Our ref: HA/2021/122984/01-L01
Your ref: CM/8/21/PL
Date: 09 March 2021

CONSTRUCTION OF SITE PERIMETER BUNDING & ASSOCIATED PLANTING TO PROTECT AGAINST FLOODING, ASSOCIATED EXCAVATION OF A POND (RETROSPECTIVE) & CONSTRUCTION OF FLOOD DEFENSE GATES (RESUBMISSION FOLLOWING CM/25/20/PL)

CLIMPING COLLEGE THE MILL THE MILL LODGE CLIMPING STREET CLIMPING BN17 5RN

corten flood wall and gate
CM_flood wall + gate
Scale: 1:100 + 1:50 @ A2
Date:18.01.2021

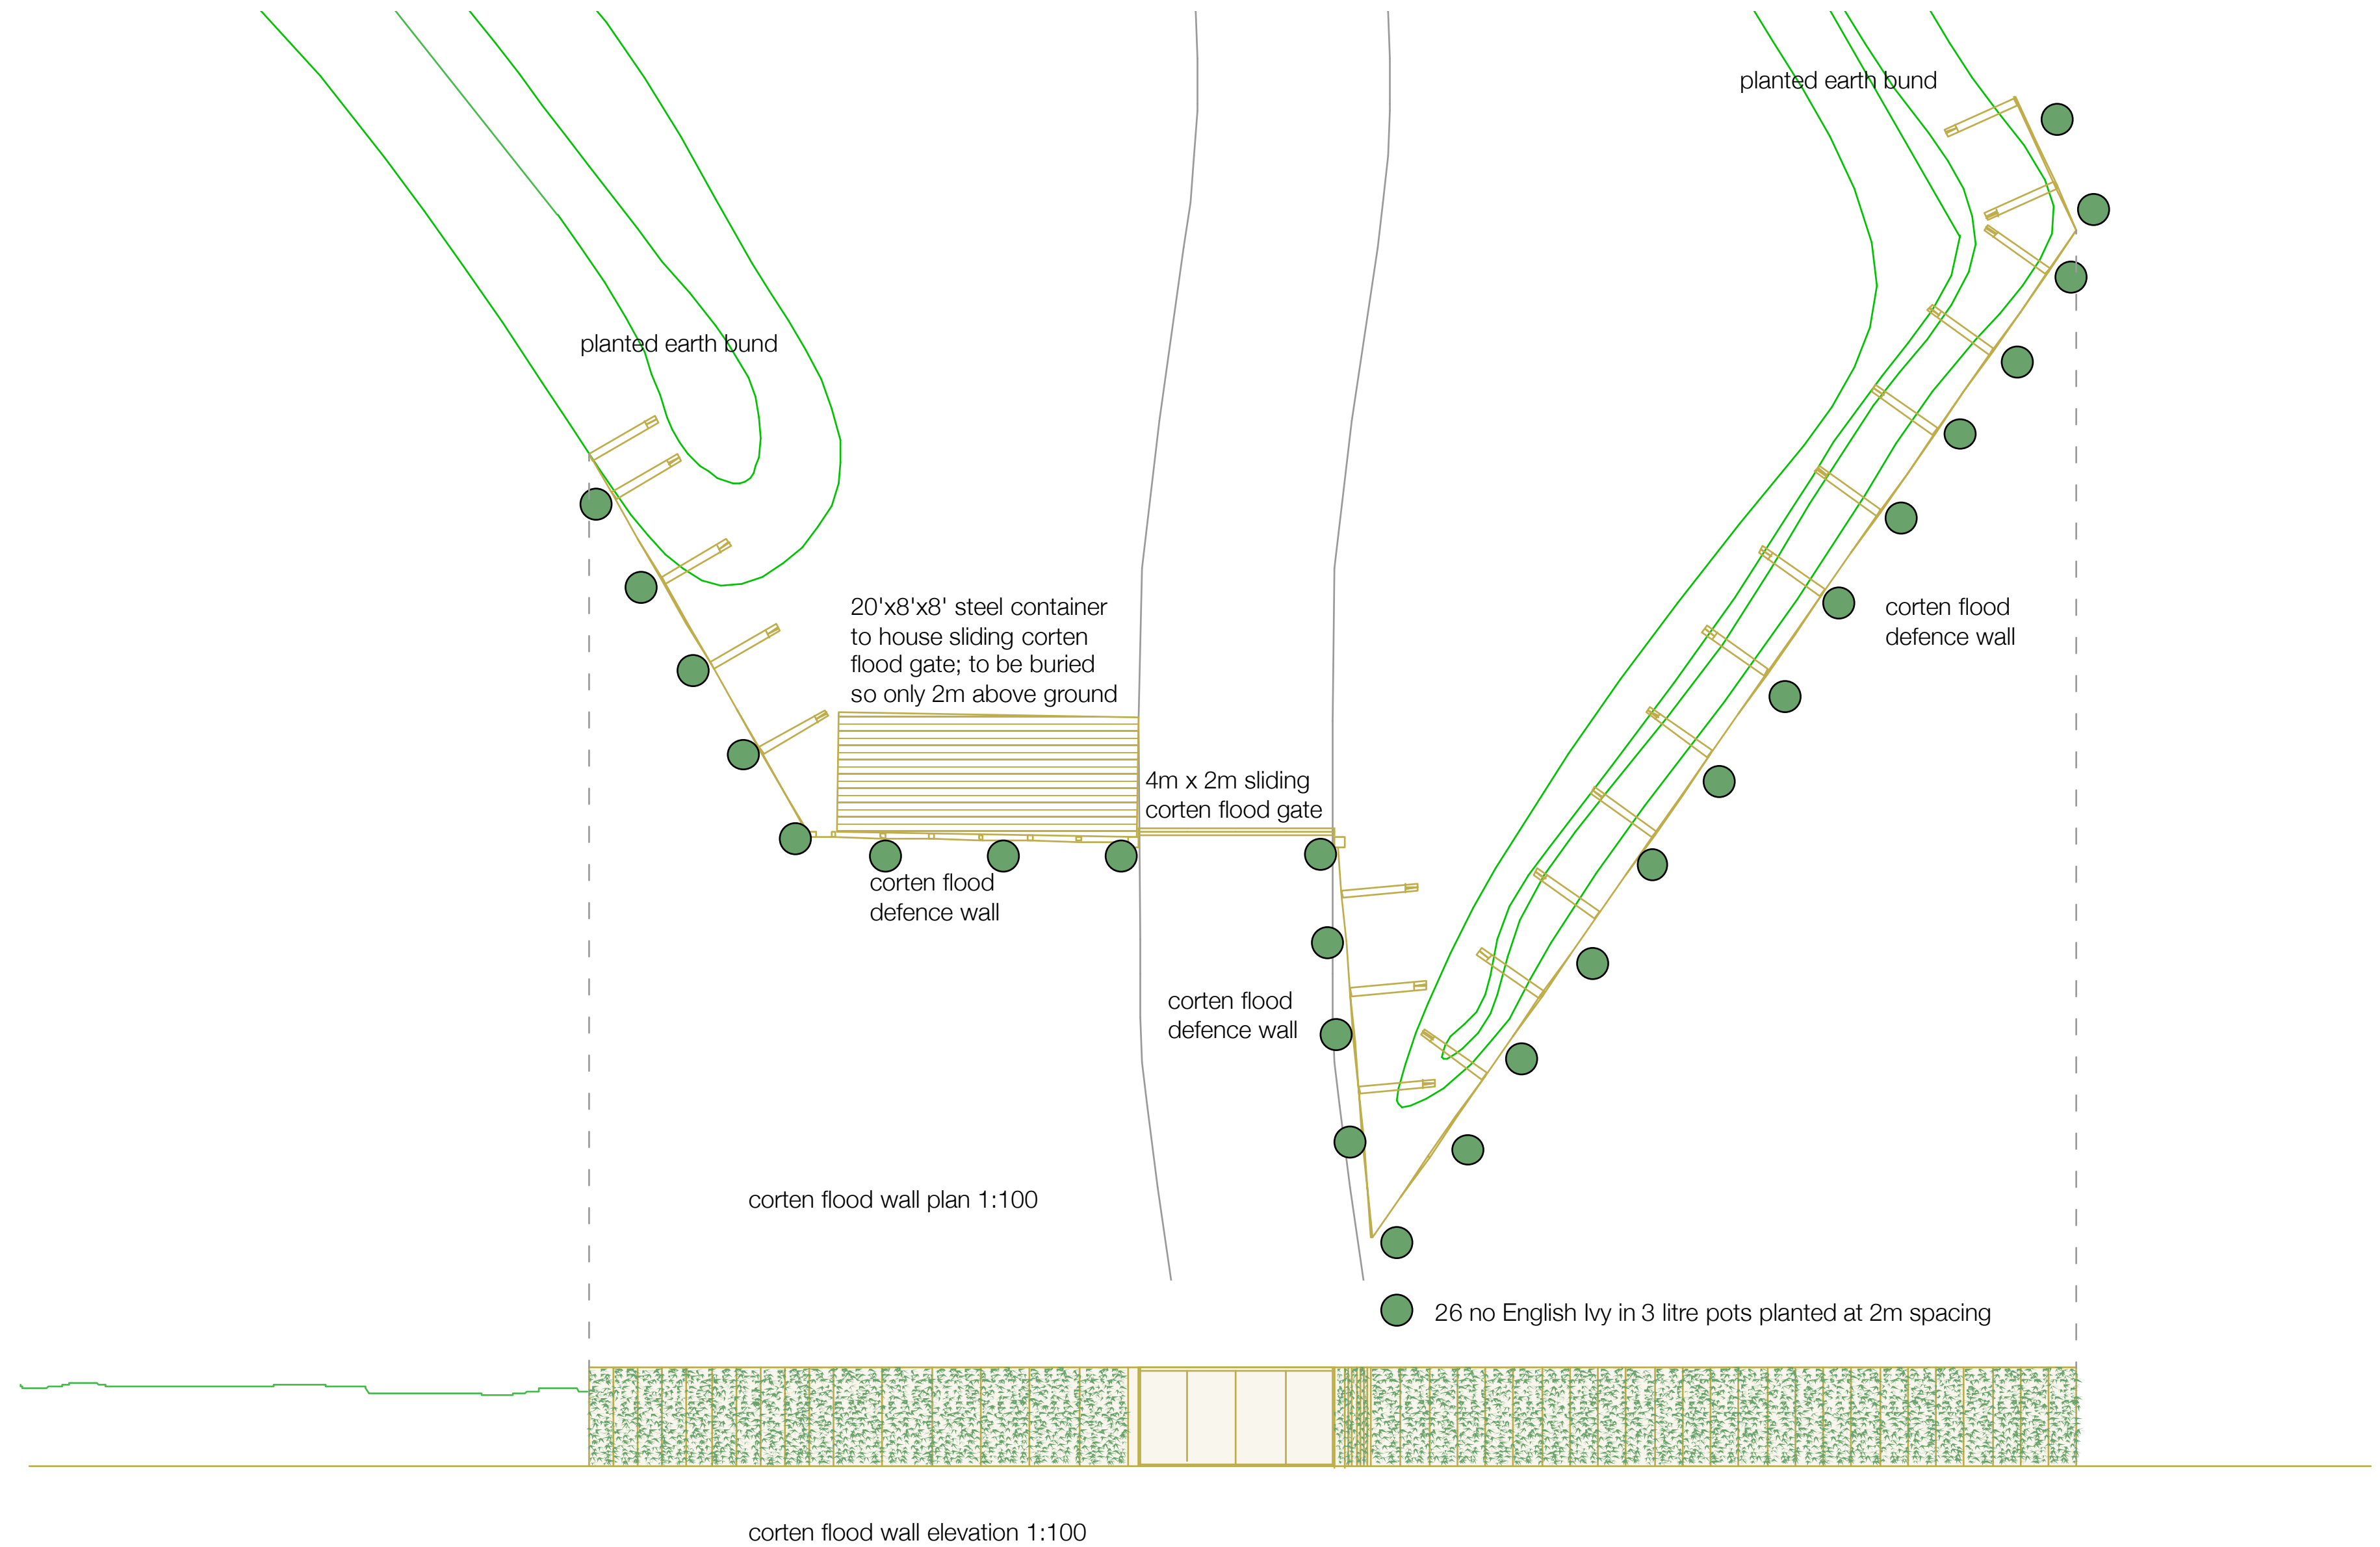
We advise consideration should be given to the effects of climate change and sea level rise on the design of the proposed earth bunds and flood gates. The installation and maintenance of the flood gates and earth bunds around the existing property will be the responsibility of the landowner.
